Subject: Bicester Gateway - Phase 2 (Albion Planning Applications - OBJECTION)

TECHNICAL NOTE

Job Name: Bicester Gateway Phase 1B Residential
Job No: 46463
Note No: TN004
Date: 17/10/2019
Prepared By: Francois Chate
Subject: Review of Transport Assessment submitted in support of Albion Scheme
(ref:19/01746/OUT and 19/01740/HYBRID)

JOB TITLE		CLIENT	
CATALYST BICESTER		ALBION LAND	
DRAWING TITLE			
WENDLEBURY ROAD FOOT/CYCLEPATH ENHANCEMENT WITH HEALTH AND RACQUETS CLUB			
SCALE	DRAWN BY	DATE	DRAWING No
1: 500@A1	RJM	03/05/19	19539-12-01
			REVISION
			B

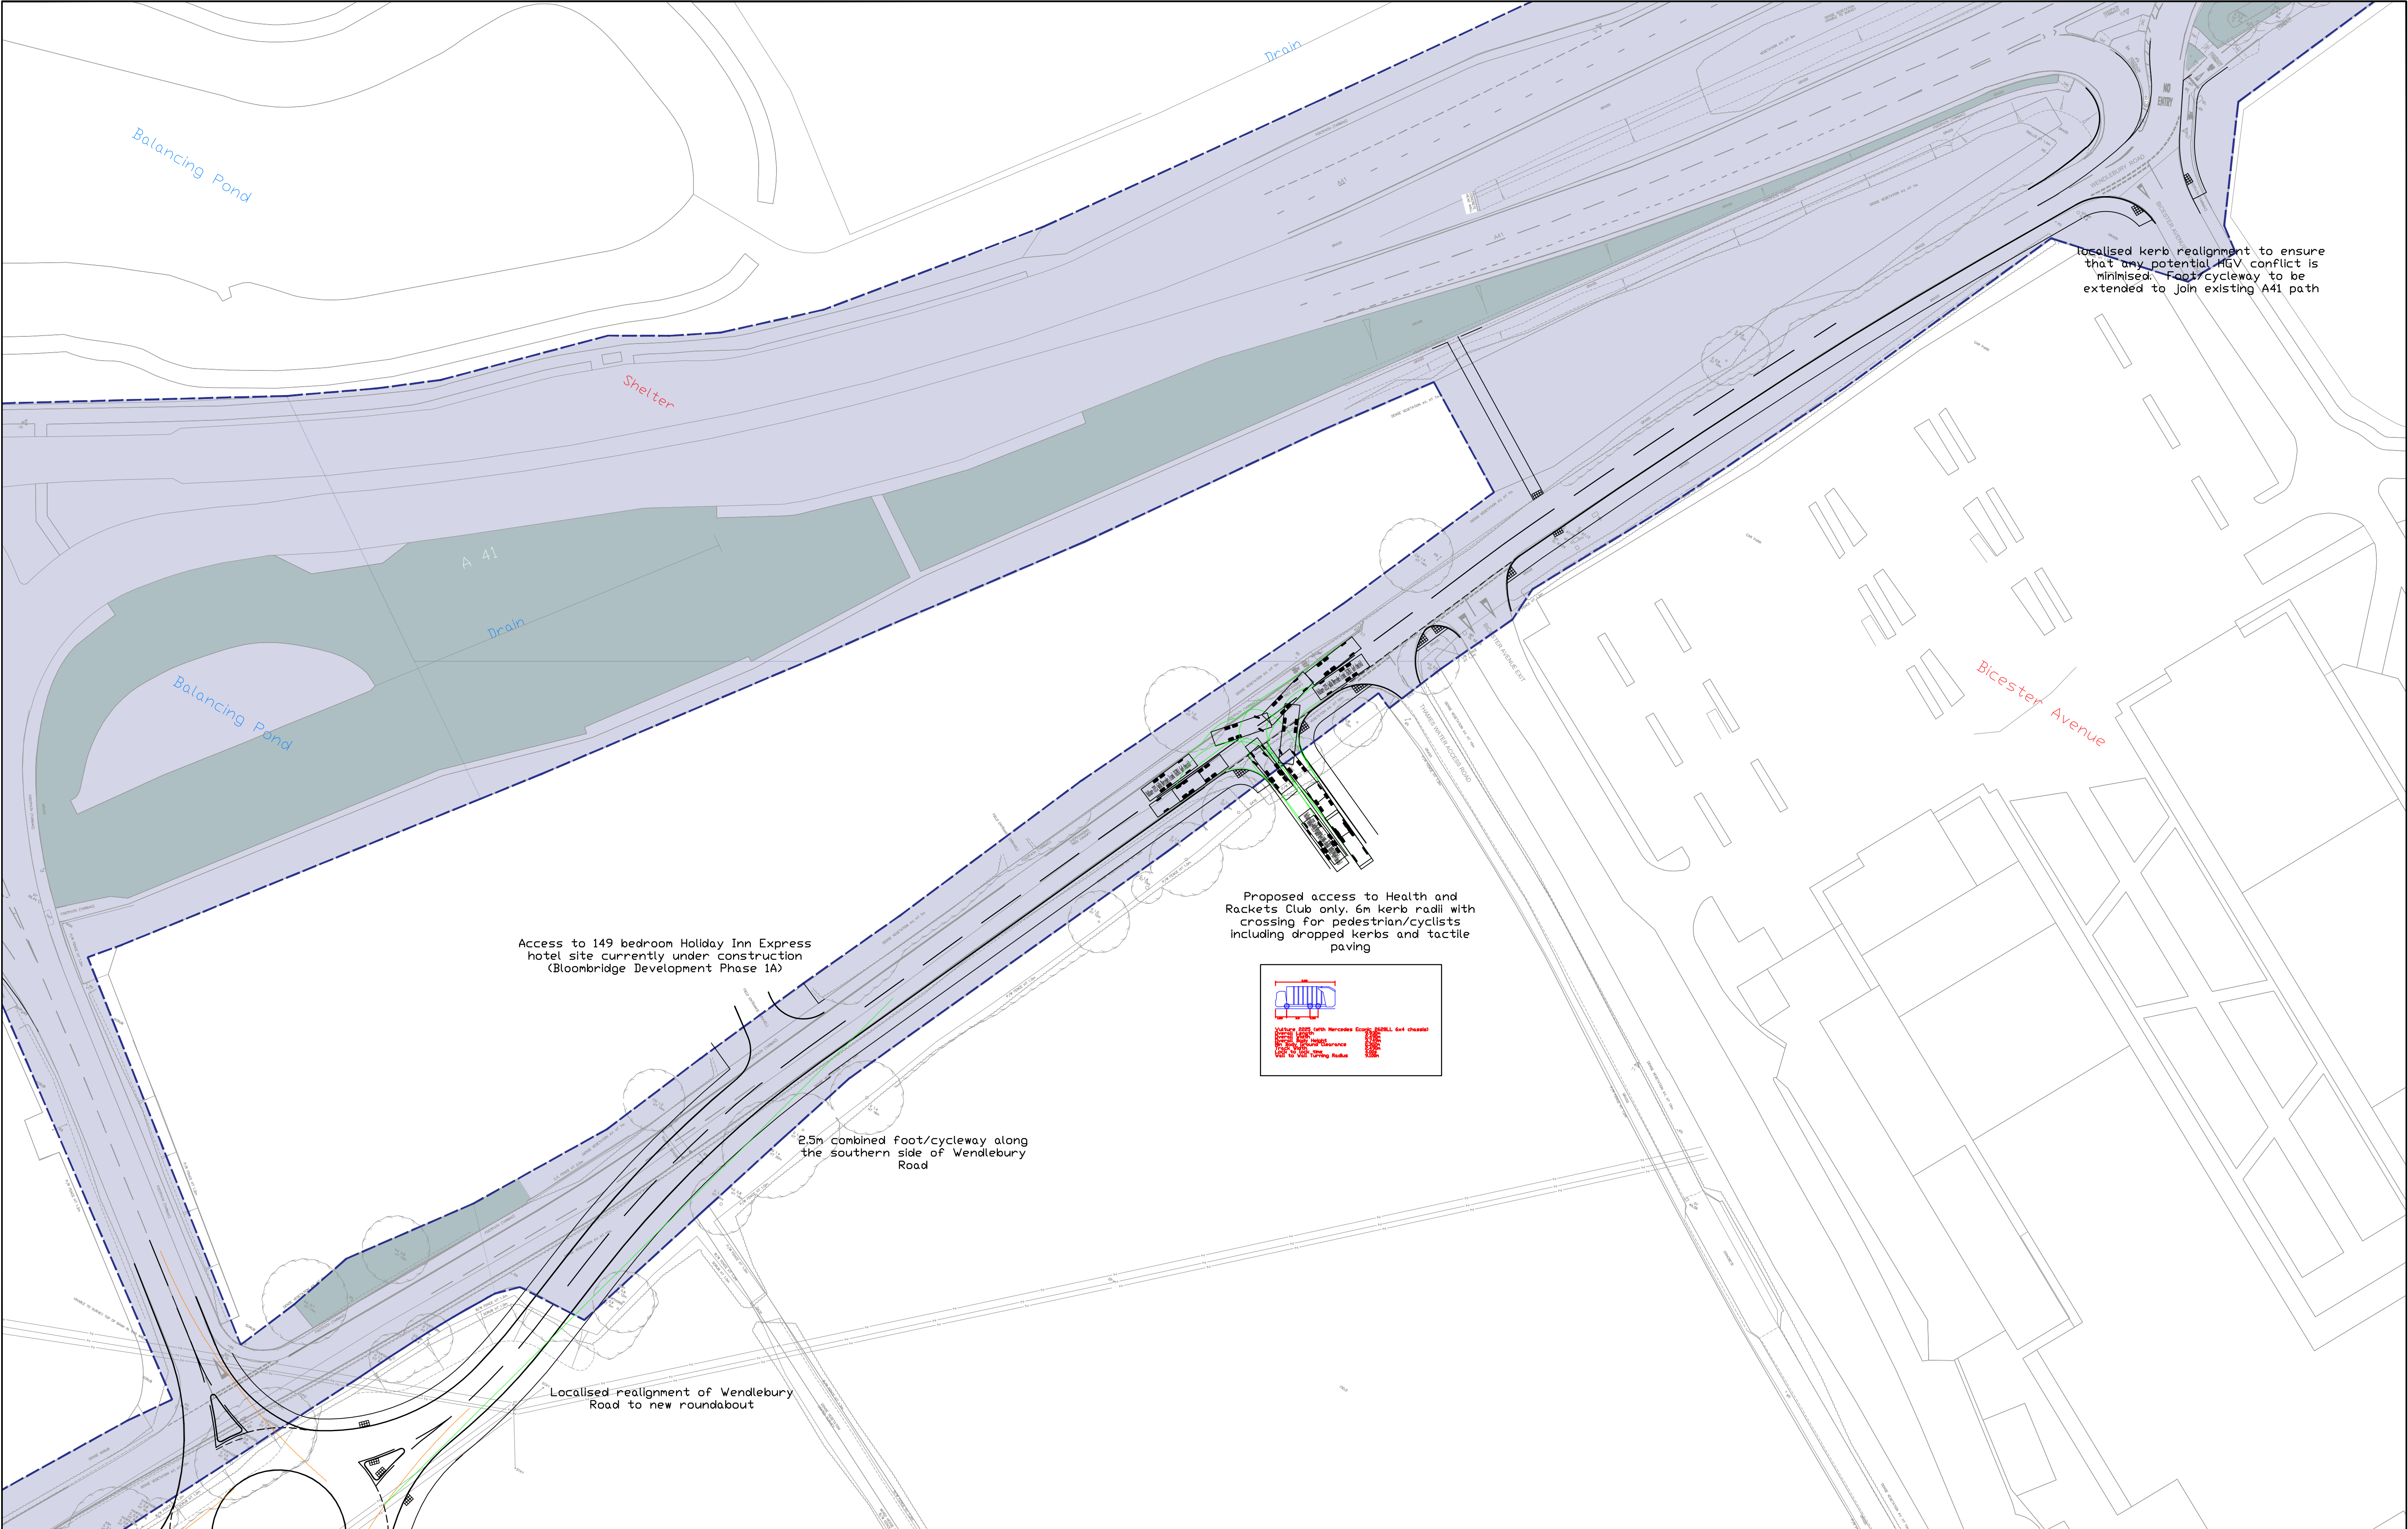
- The Albion TA puts forward a proposed 2.5m-3m shared footway/cycleway along Wendlebury Road north of Vendee Drive (link). This would then connect to a new pedestrian link across highway land available north of the Hotel plot linking with the A41 and the committed bus stops and pedestrian crossing there. There are a number of potential issues with these proposals:

- 3m is the typically accepted minimum width for a shared footway/cycleway (ref: LTN1/12) although it is accepted that OCC would allow a minimum width of 2.5m for such a facility. However, the Albion TA presents the outcome of a Road Safety Audit (RSA) of the proposed facility. This RSA suggests that the proposed footway/cycleway should be flanked by a barrier or land between the footway/cycleway and the site regraded accordingly. The Albion TA accepts this recommendation (see paragraph 5.5.3 in the Albion TA). If a barrier is proposed at the back of the footway/cycleway this will impact the effective width of the cycleway, and, in this context, it would be recommended that the minimum overall width of the shared footway/cycleway be set at 2.75m. The question therefore arises on whether Albion Land would be able to deliver such a facility within the land available to them and local physical and environmental constraints. PBA would expect OCC to request suitably detailed scheme drawings showing this facility incorporating the RSA suggested changes, to provide sufficient certainty of deliverability.

- The proposed shared footway/cycleway on Wendlebury Road (north) would probably form the most direct route for users of the Albion Land schemes located at the northern end of the Albion Land sites, assuming they can access the facility directly and without having to travel to the proposed new access roundabout (something which is not guaranteed given the impermeable design of the proposed Health and Racquet Club). For all other site users, the most logical pedestrian and cycle route out of the Albion Land site and to the facilities on the A41 is via Vendee Drive (link). PBA considers this route to form the most likely desire line for most site users. PBA would expect OCC to request that Albion Land reconsider their access strategy to recognise the important role that Vendee Drive (link) plays in the accessibility to the Albion Land schemes, notably in relation to the potential for a shared route for cyclists and pedestrians alongside that link.

JOB TITLE CATALYST BICESTER		CLIENT ALBION LAND	
DRAWING TITLE WENDLEBURY ROAD SITE ACCESS ROUNDABOUT			
SCALE 1: 500@A1	DRAWN BY RJM	DATE 03/05/19	DRAWING No 19539-12-02
REVISION B

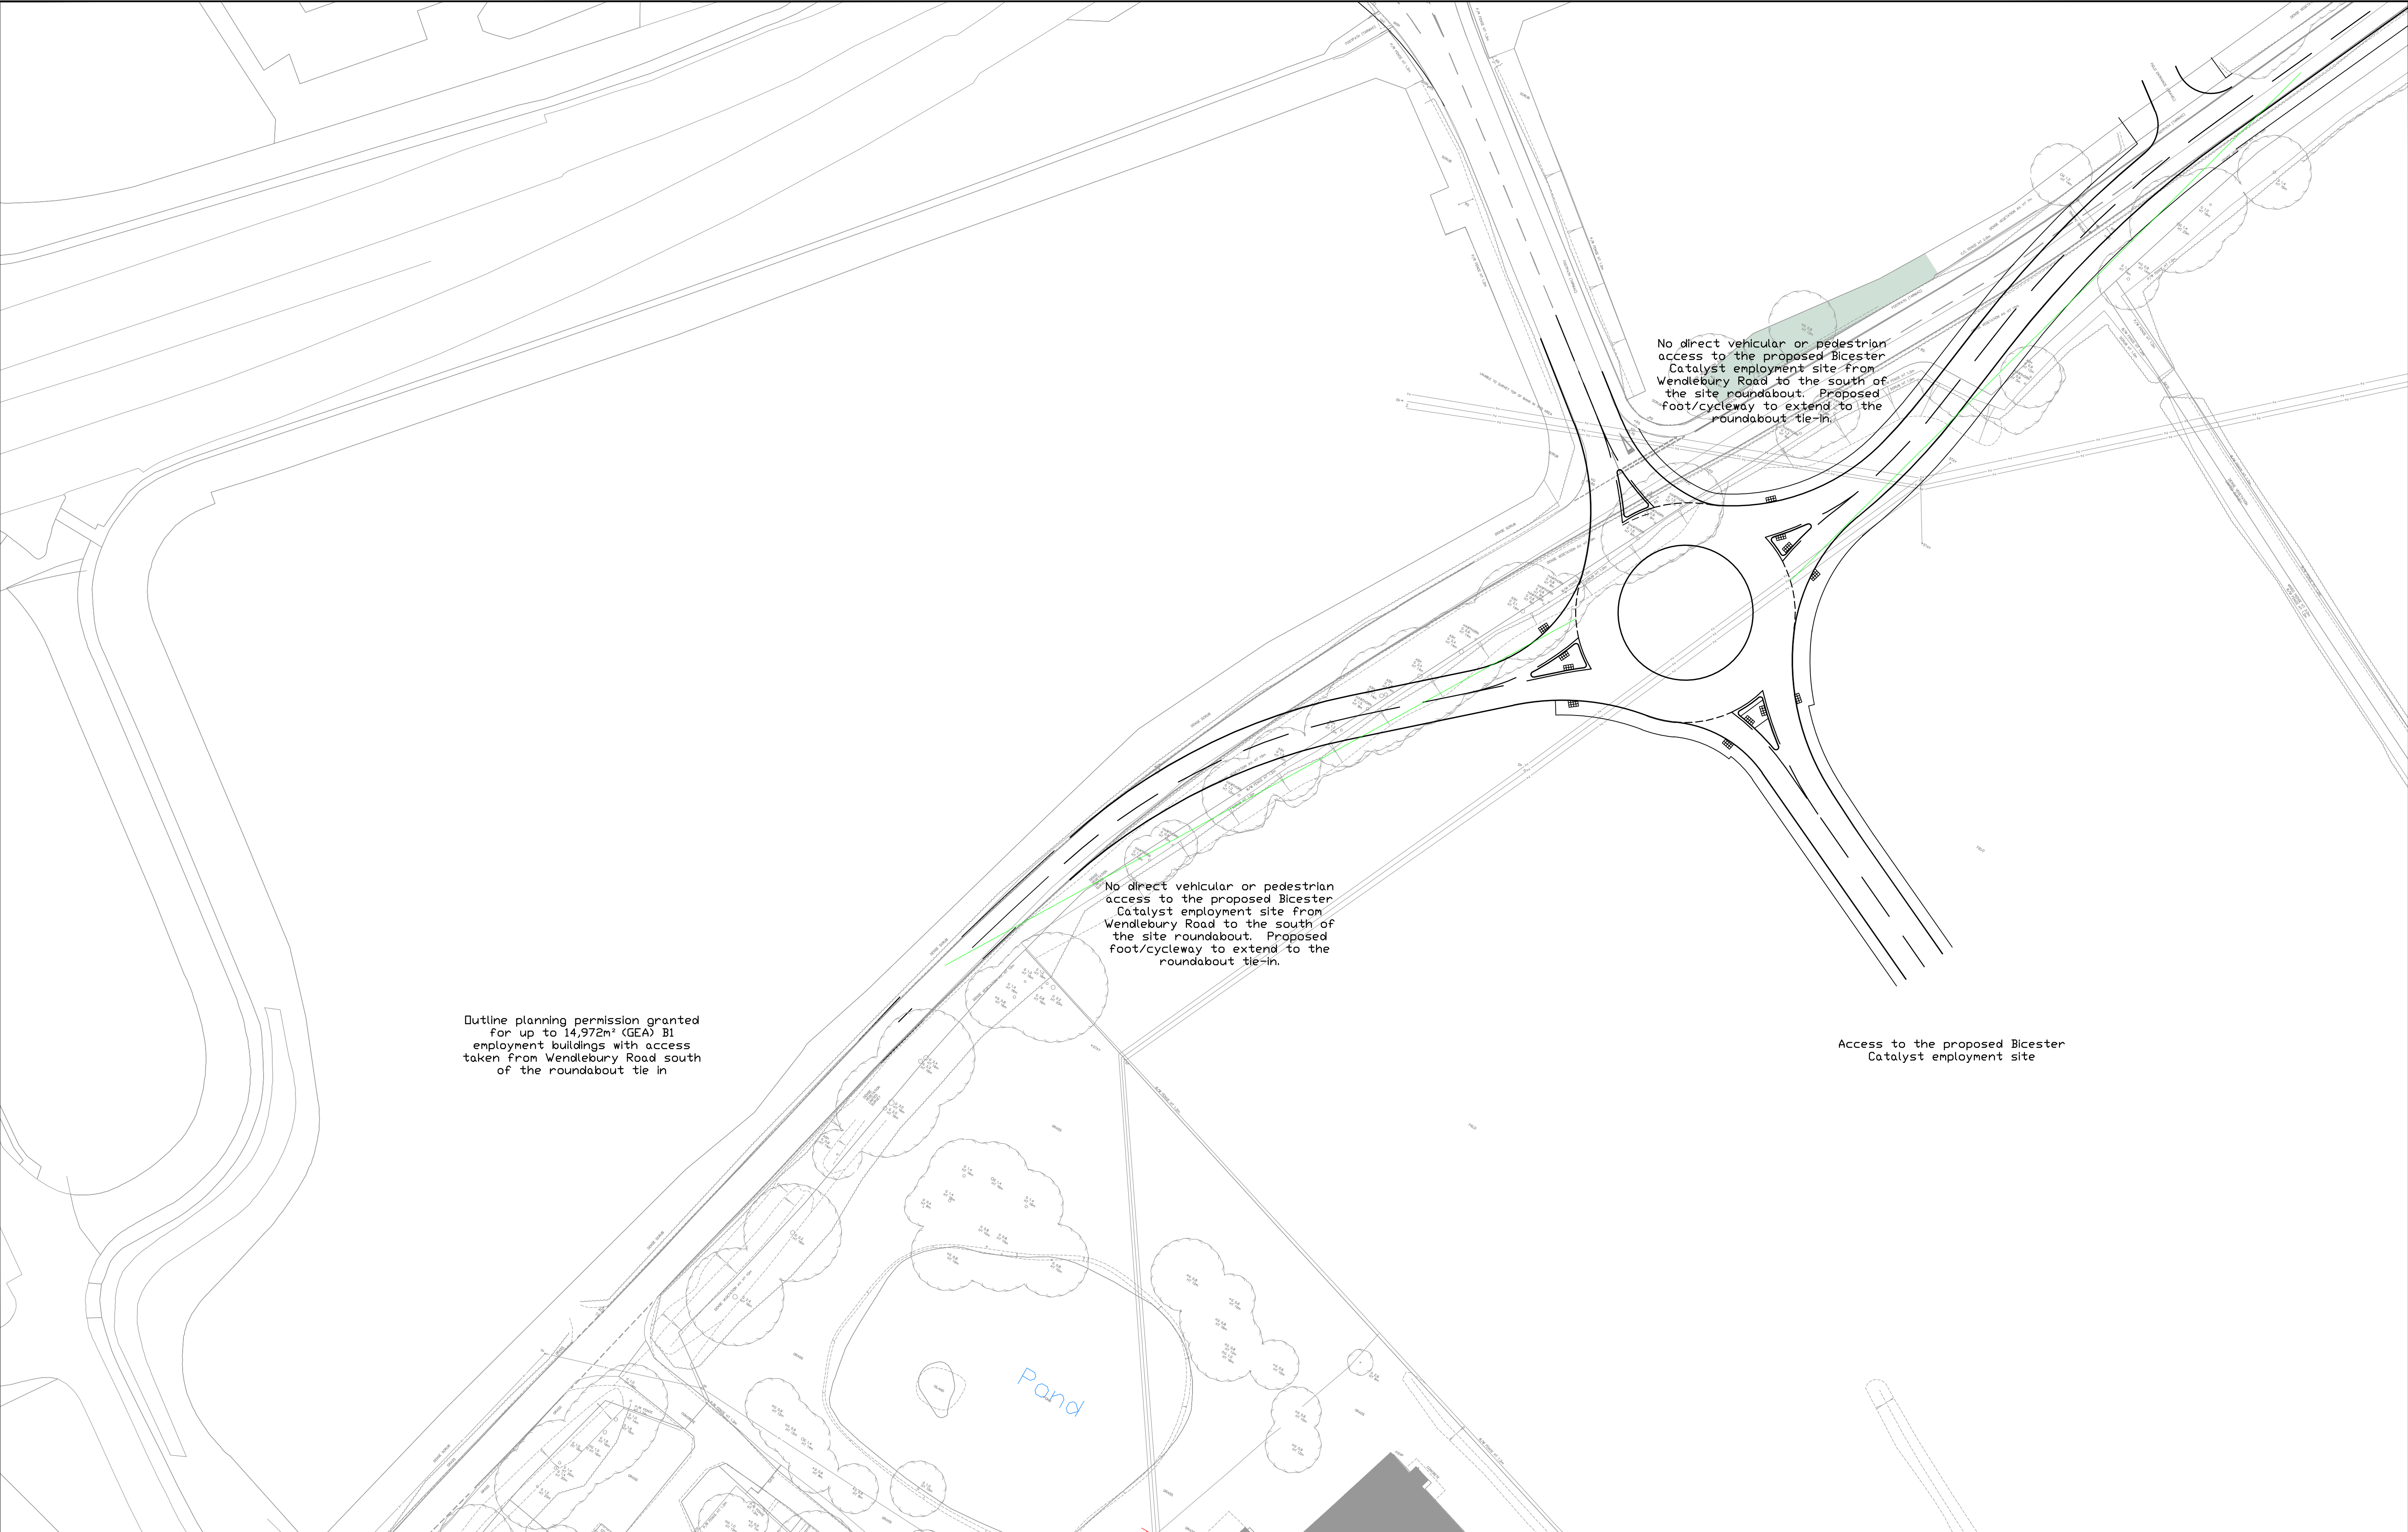
- The same RSA queries whether Wendlebury Road south of the proposed Albion Land access roundabout would be used by cyclists. The Albion TA responds by suggesting they are not providing for cyclists on the southern approach into the roundabout (see paragraph 5.5.4 in the Albion TA). This is odd as Wendlebury Road to the south is part of the National Cycle Network. Therefore, it is likely that some cyclists accessing the Albion Land schemes will come from Wendlebury Road south (i.e. from the direction of Oxford). PBA would expect OCC to request that Albion Land make provision for cyclists on Wendlebury Road to the south of the proposed site access.
